Demolition of 1 No. existing house & grounds & erection of 2 No. new detached dwellings. This application may affect the character & appearance of the Station Road, East Preston Conservation Area.

St Marys Close Hurst Road Rustington

Thank you for your internet representation made on 5th October 2018 which has been recorded as '**an objection**' with the comments as follows:

Drawing Title:
ADDITIONAL DWELLINGS
BLOCK/ SITE PLAN

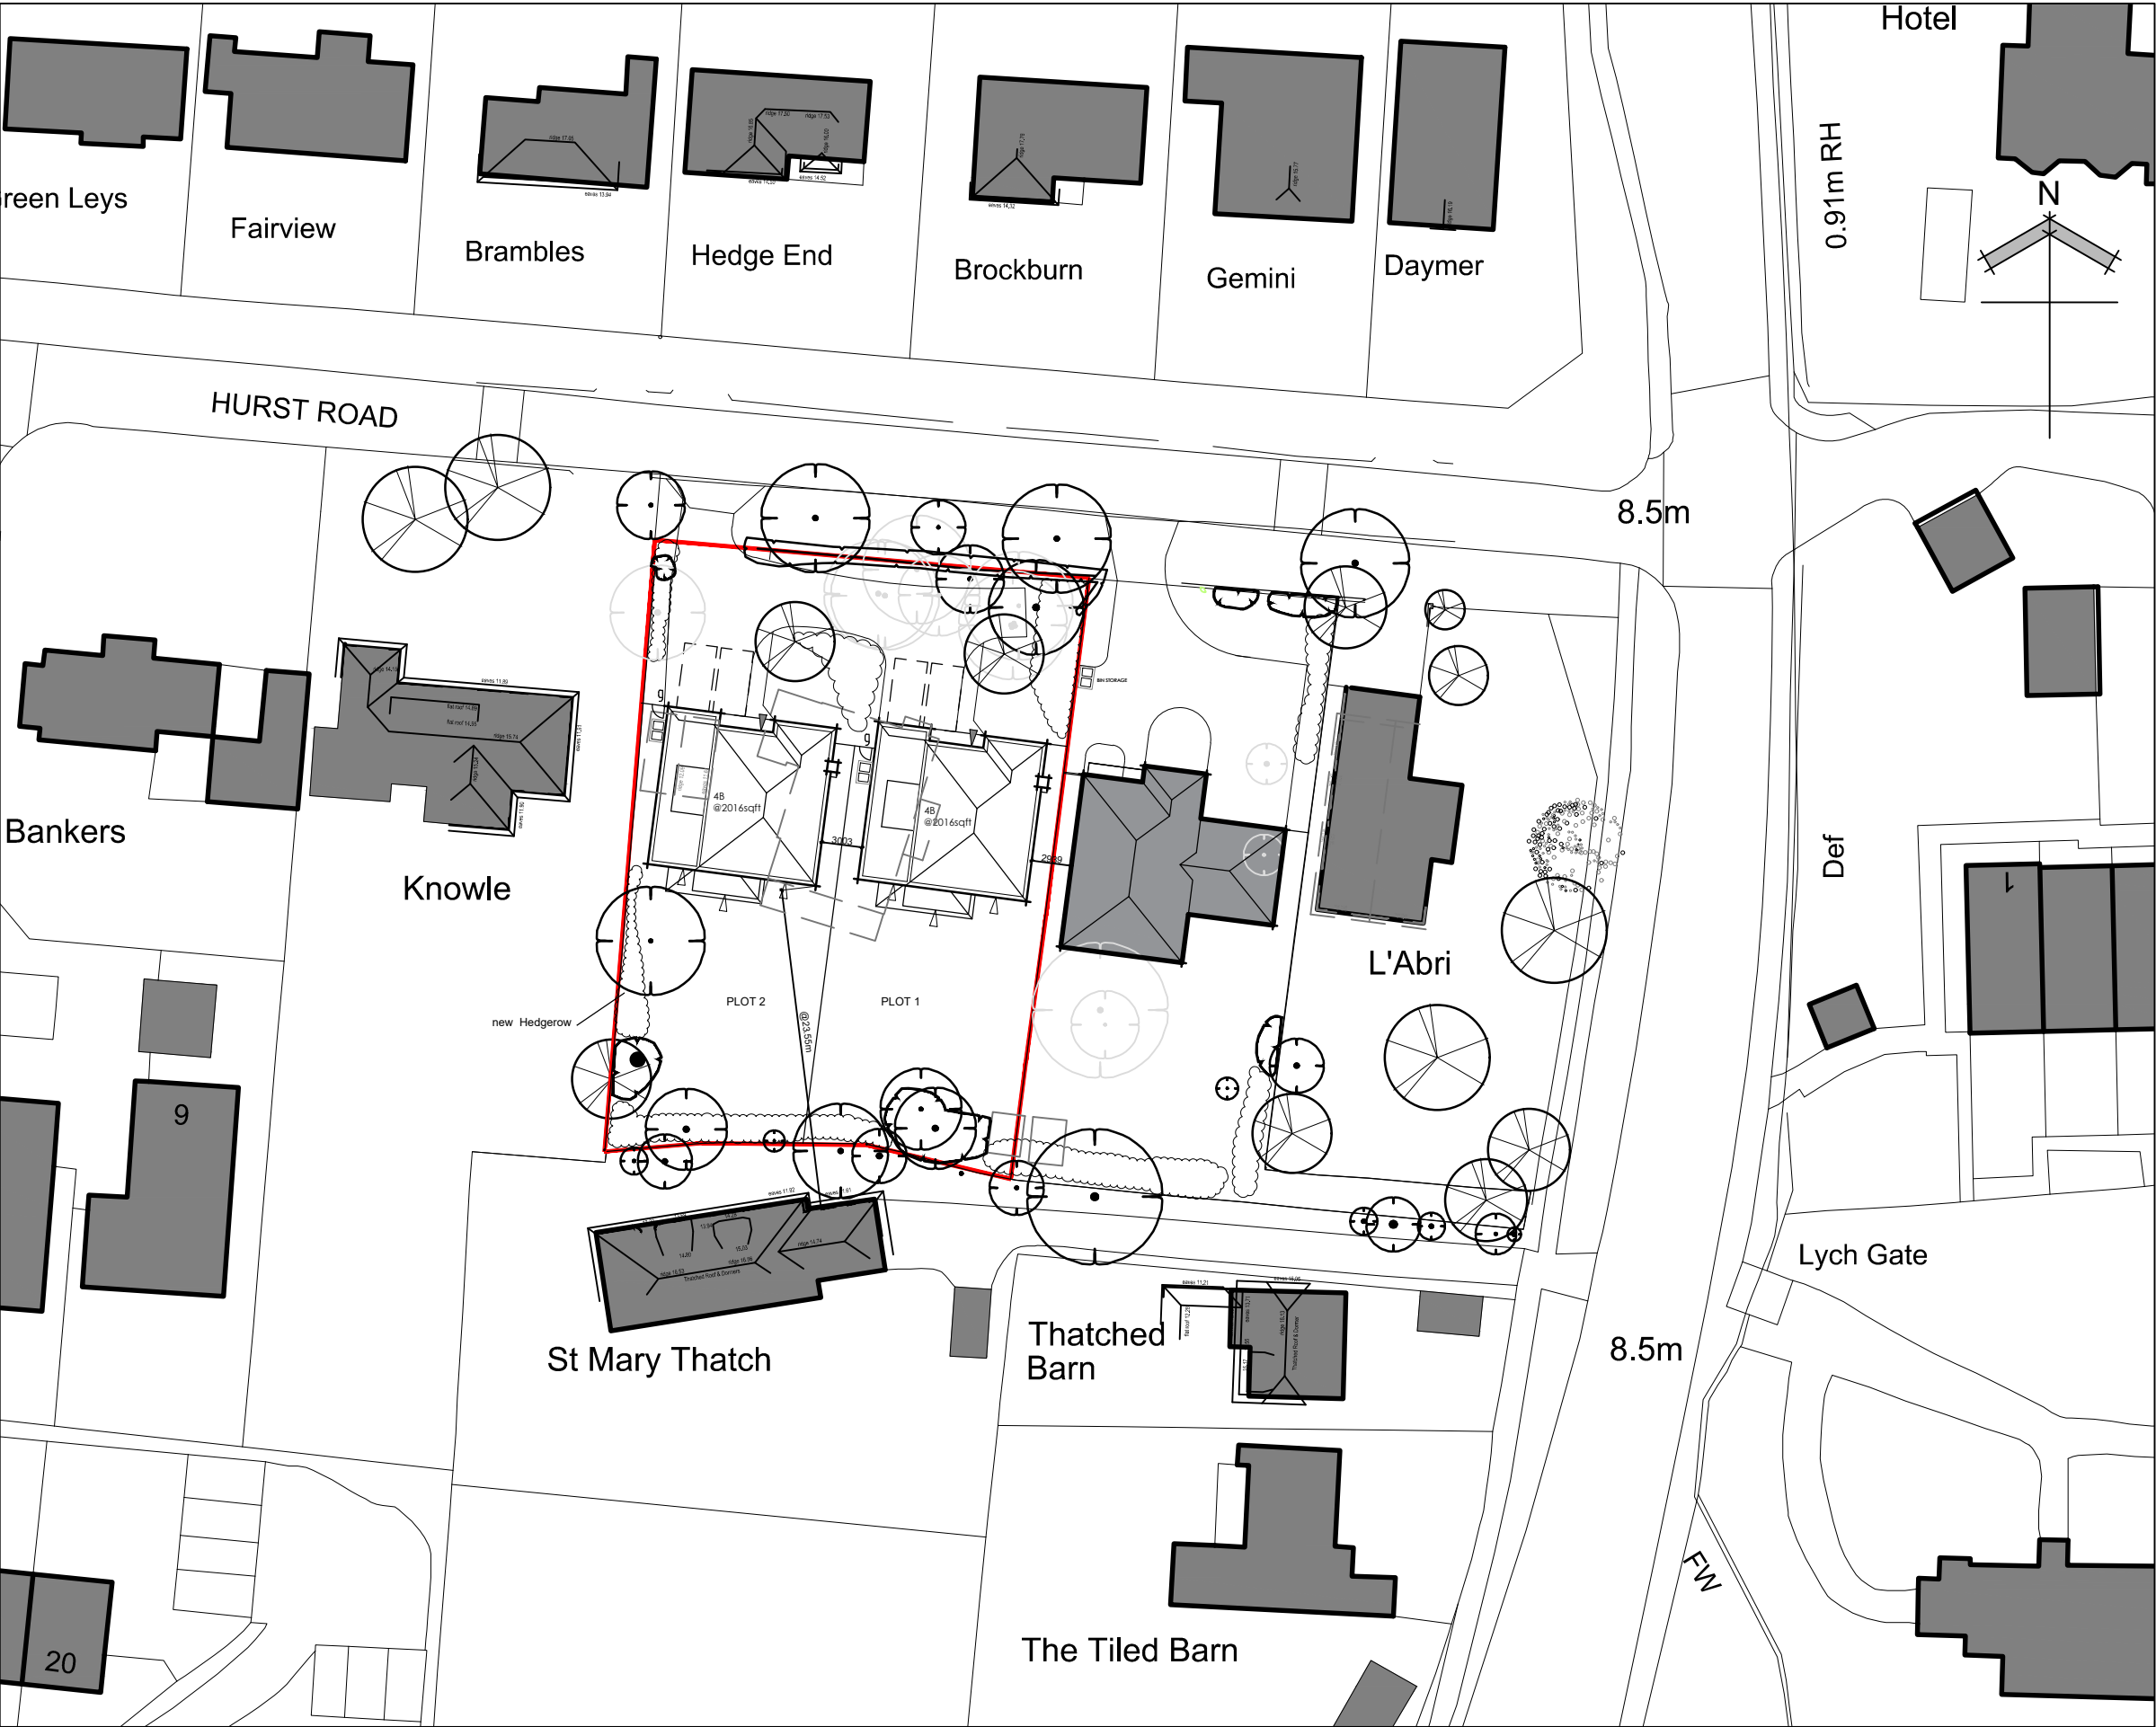
2) Both houses will share a common driveway. I feel they should have separate drives as this will clarify who is responsible for verge maintenance. This is very necessary as Hurst Road has no footpaths and a neglected verge would necessitate pedestrians walking in the road.

Drawing Title:
ADDITIONAL DWELLING
PLOTS 1 & 2
ELEVATIONS

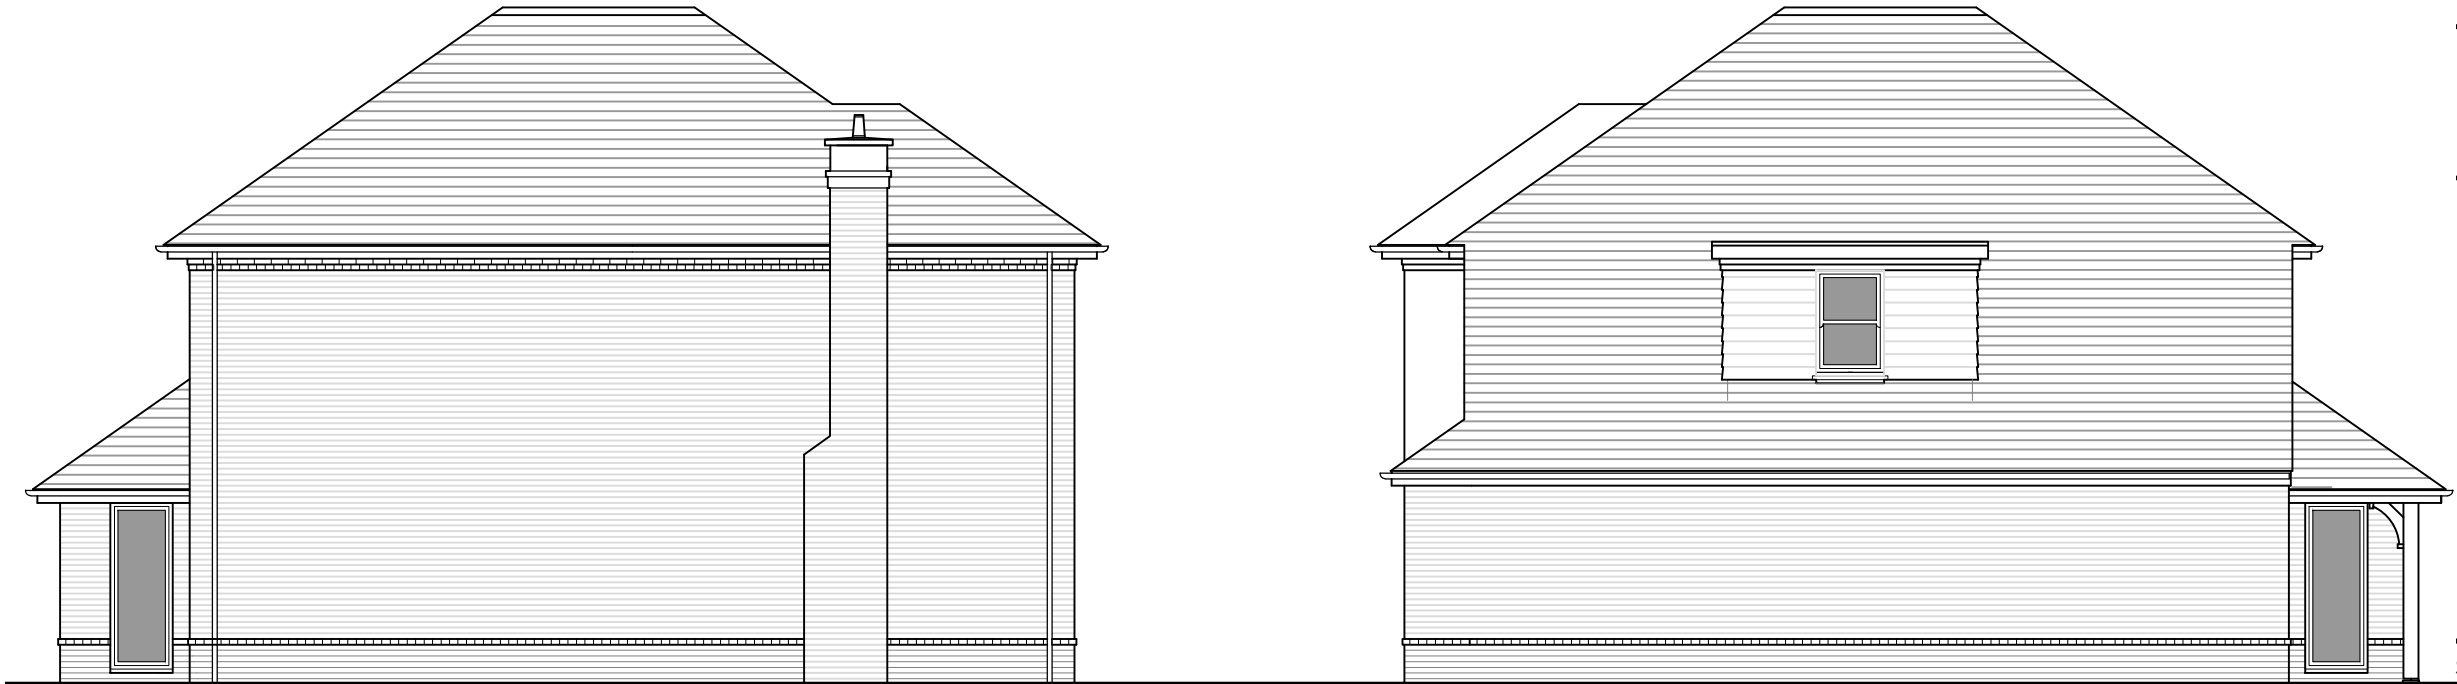
1) The developer plans to build two identical houses pointing in the same direction. This will certainly have a detrimental effect on the road as all the other houses are of non-identical designs.
